Our Ref: WA/55/11/

14th June 2011

**Removal of part existing roof with parapet walls. New first floor extension top form master bedroom suite
Swallow Shaw The Street Walberton**

PROPOSED FIRST FLOOR PLAN

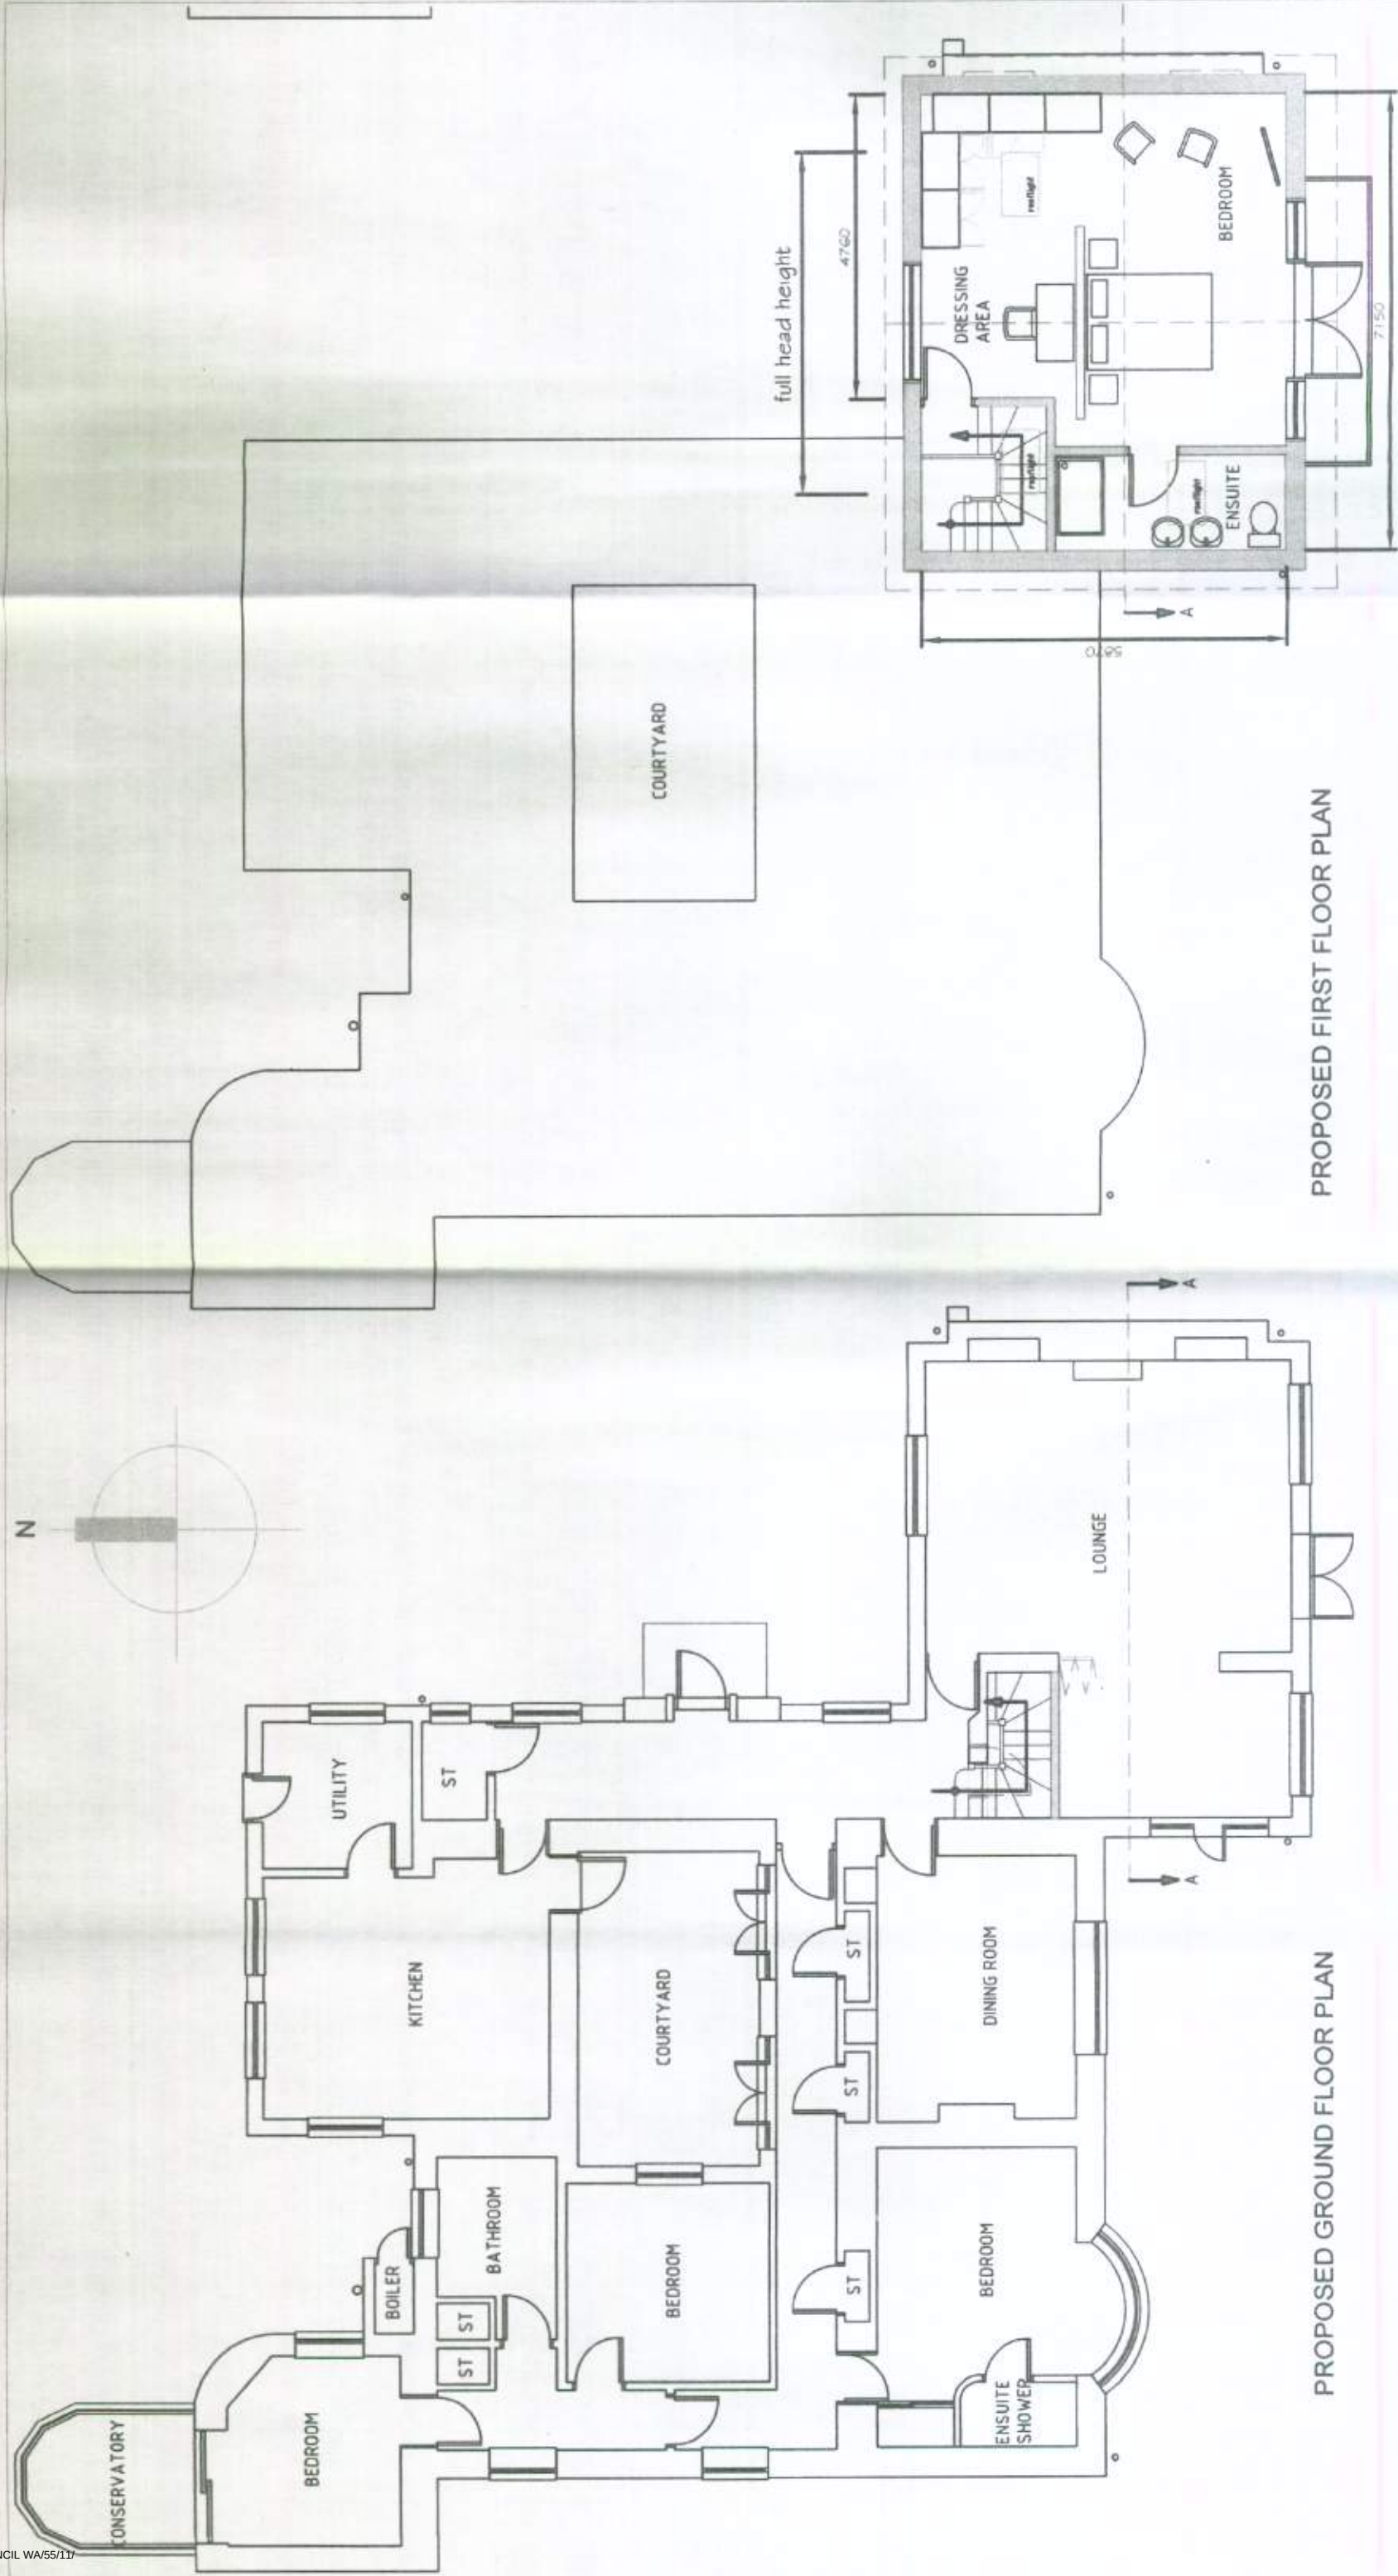
Please provide 1 electronic or 3 paper copies of revised proposed elevations as the First floor plan and elevation do not match, in accordance with the guidance notes available on our website detailed below (click on National List).

DRAWING
**EXISTING & PROPOSED
ROOF PLANS**
DRAWING No.
40/08 P.A.
SCALE 1:100
DATE JUNE 2011
REVISION
DRAWN LA
CHECKED

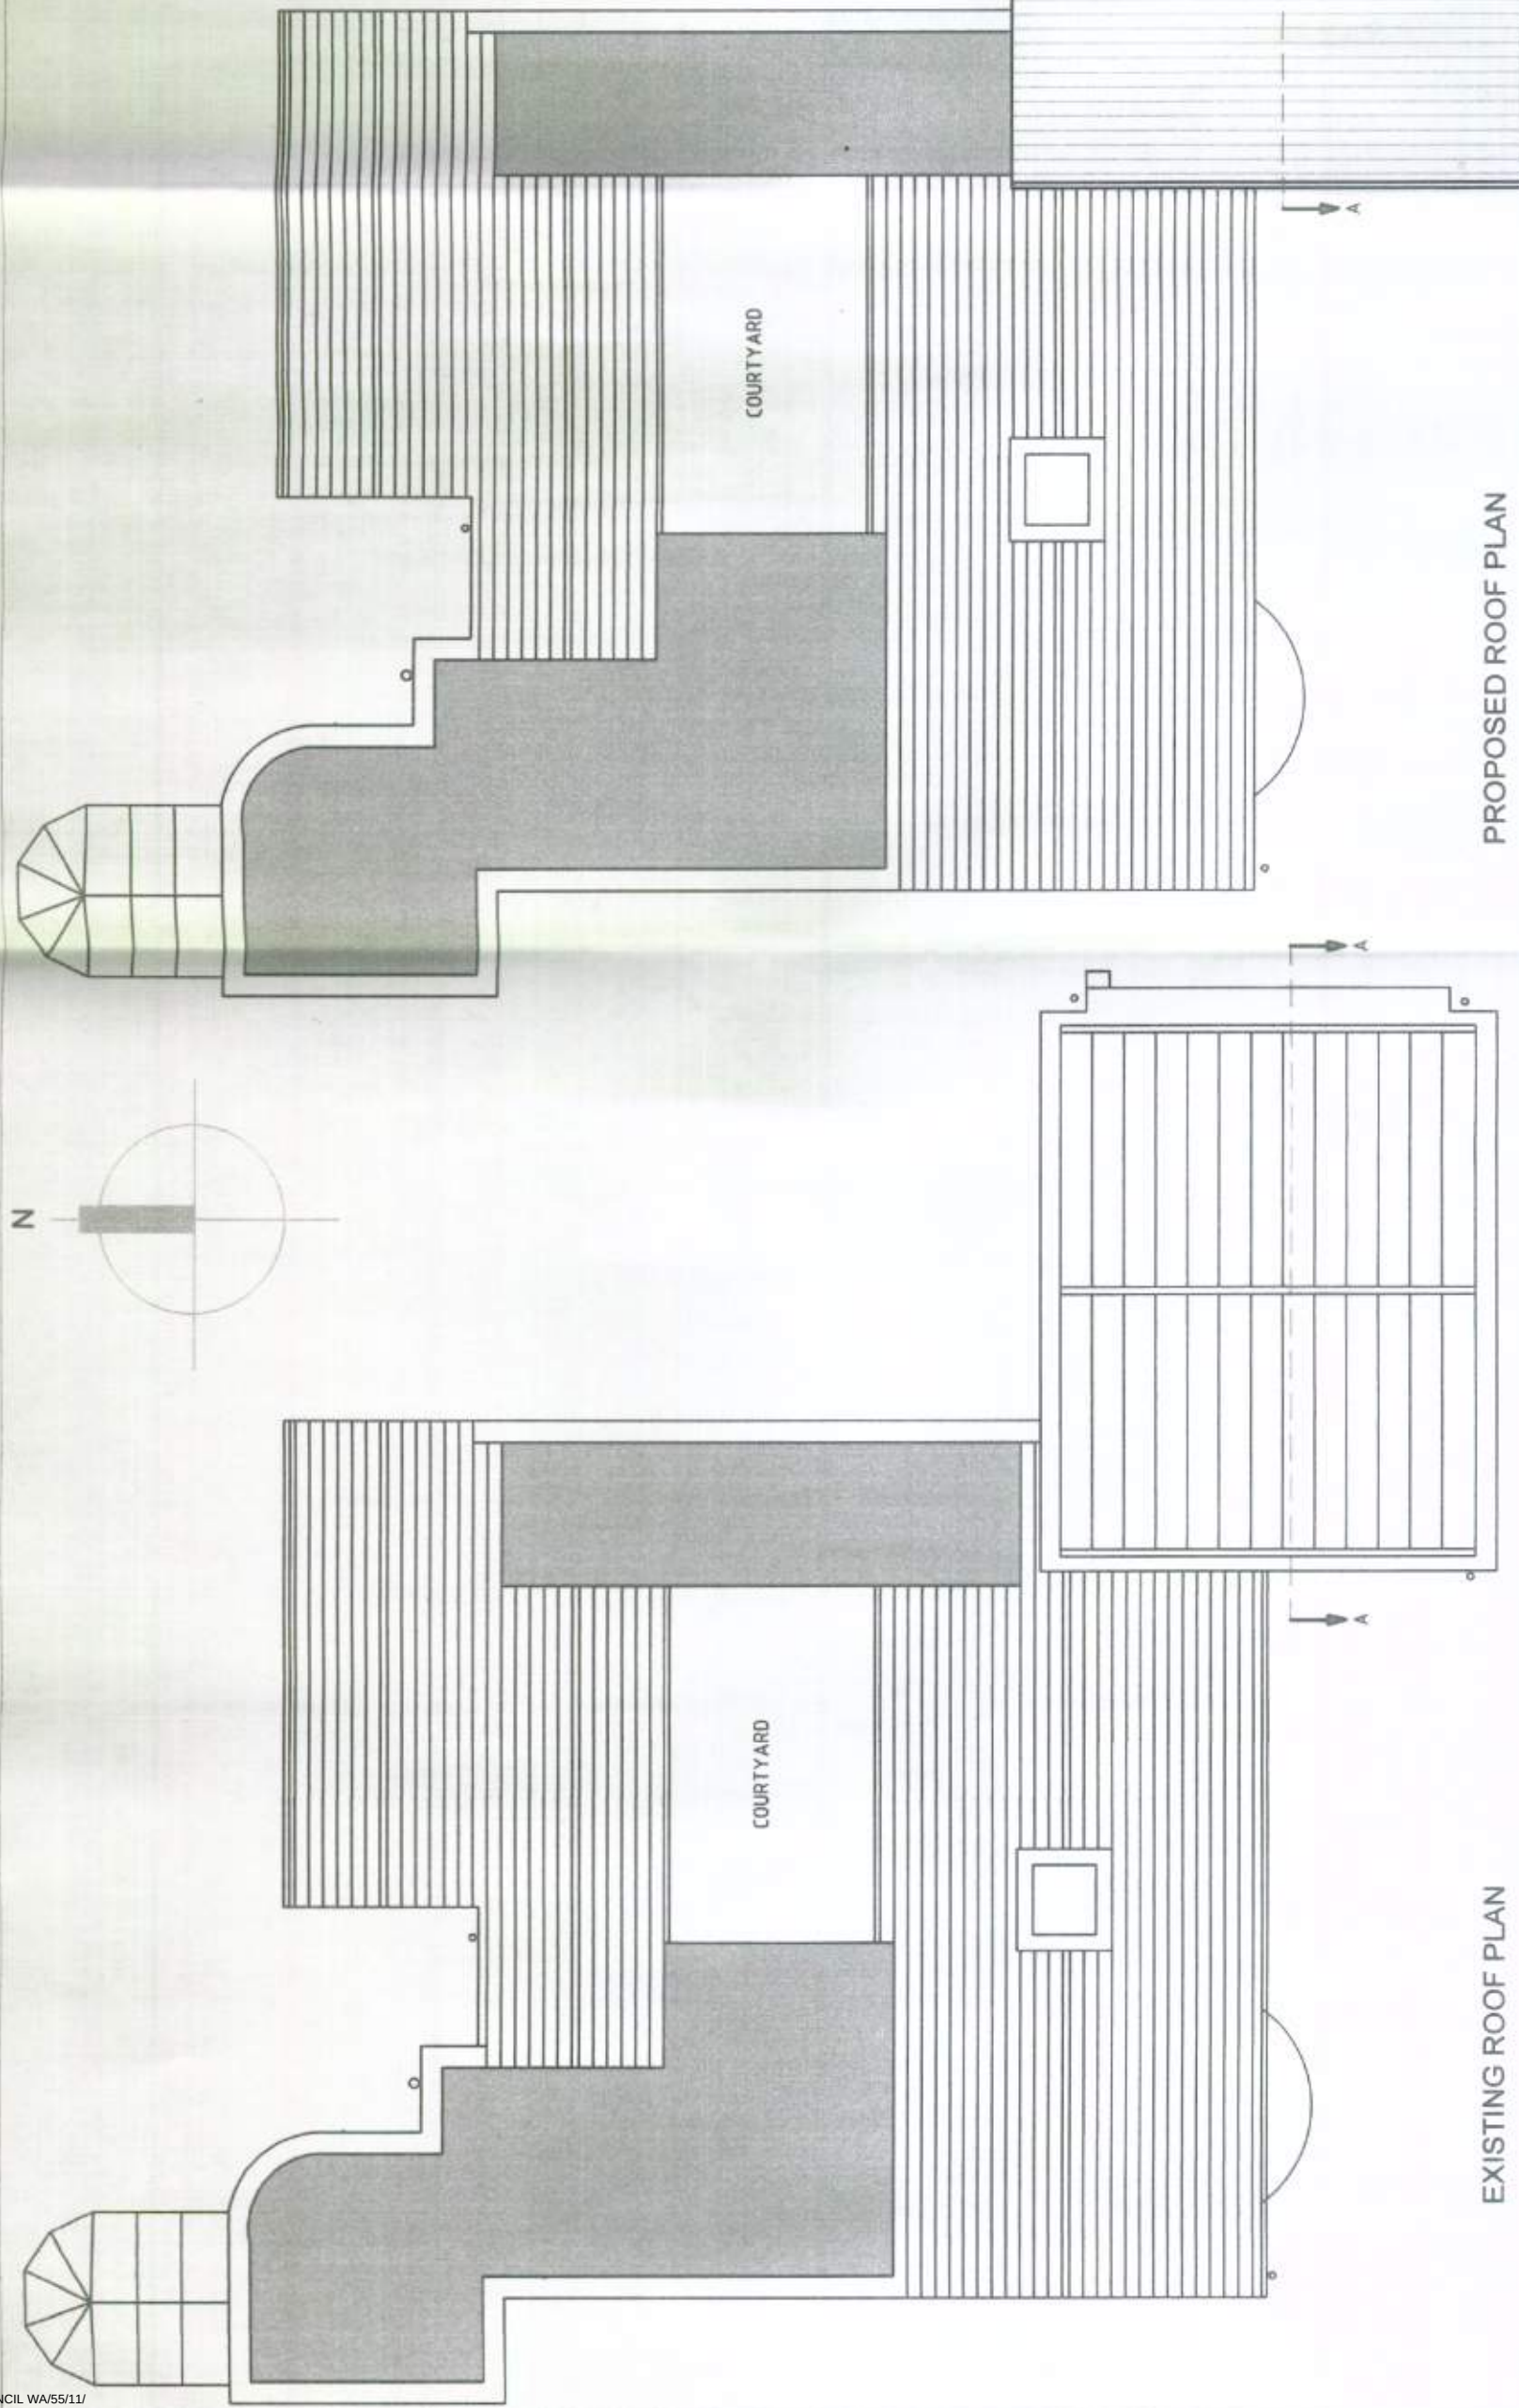
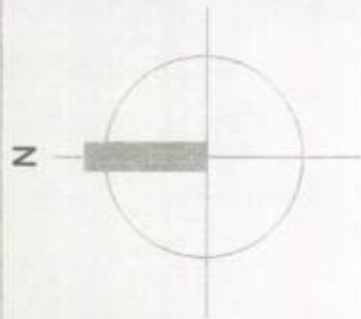
Please submit 1 electronic or 3 paper copies of existing and proposed roof plan in accordance with guidance notes available on our website detailed below (click on National List).
